Our Ref: LU/176/17/PL
Your Ref:

Town & Country Planning Act 1990 (as amended)
Town and Country Planning (Development Management Procedure) (England) Order 2015
Application for Planning Permission

Development Replace timber framed windows for PVCu
Location 3A Norfolk Road Littlehampton

BLOCK 1:200

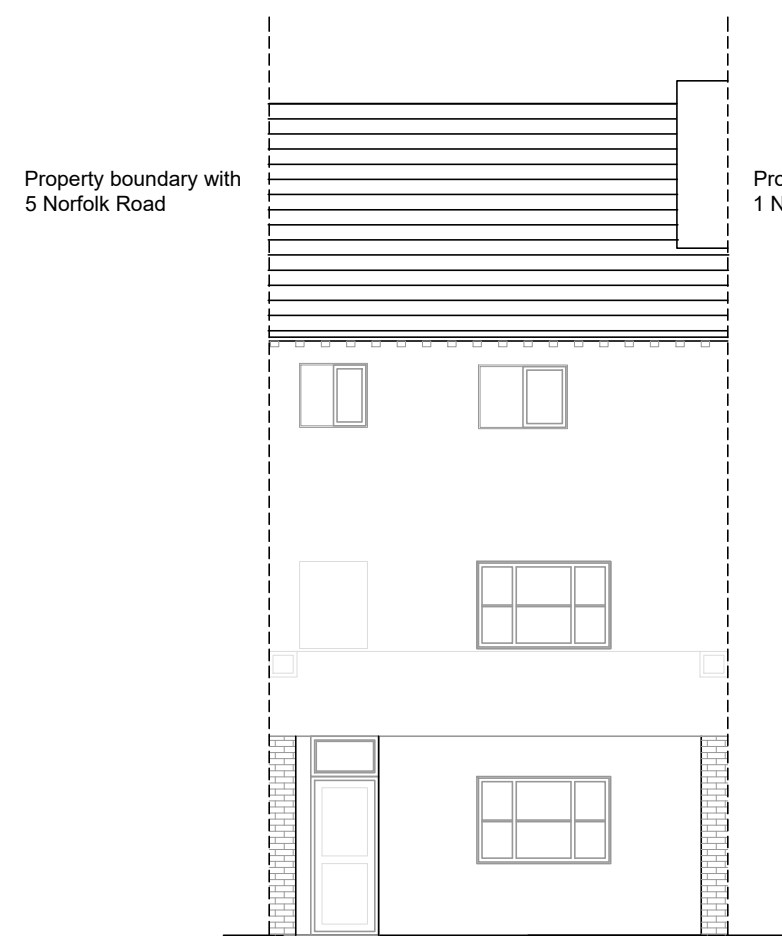
Block Plan - revised

Please submit 1 electronic or 3 paper copies of a revised block/site plan at a scale of 1:500 or 1:200 with the windows highlighted. Further details of what must be included on the plan can be found in the National Validation Requirements.

EXISTING ELEVATIONS 1:100

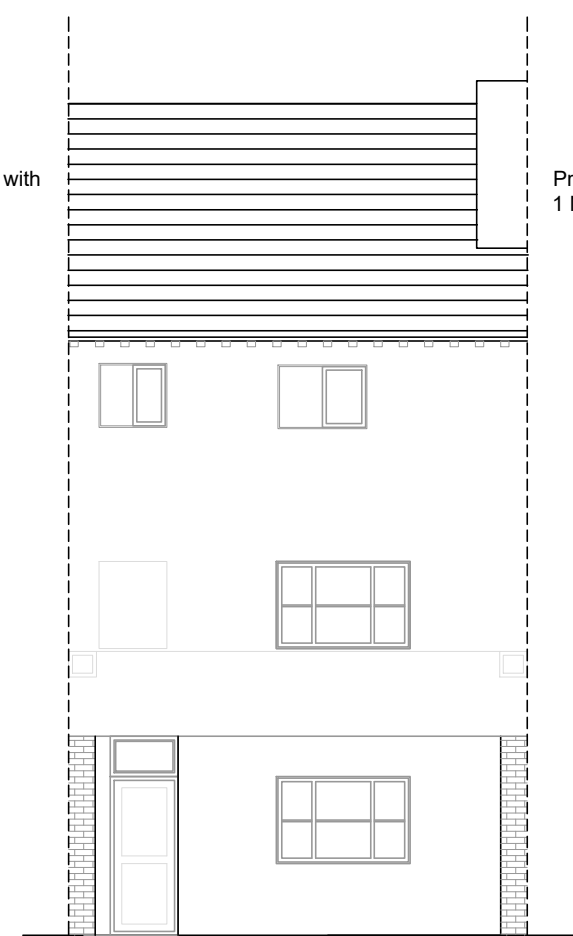
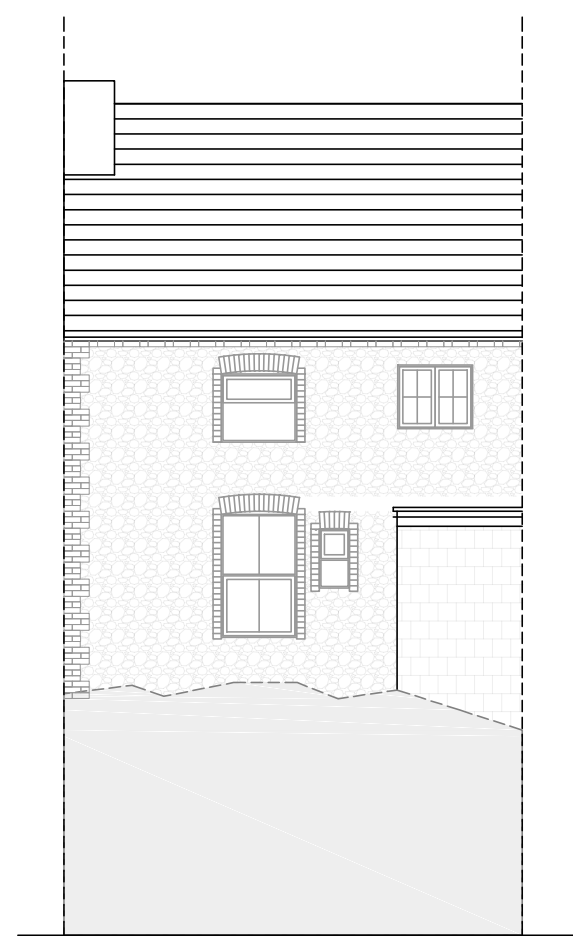
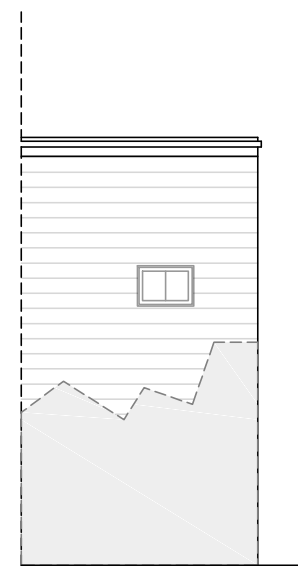
Please confirm if all windows are to be replaced - if not please highlight the elevations with the windows affected by the application clearly highlighted.
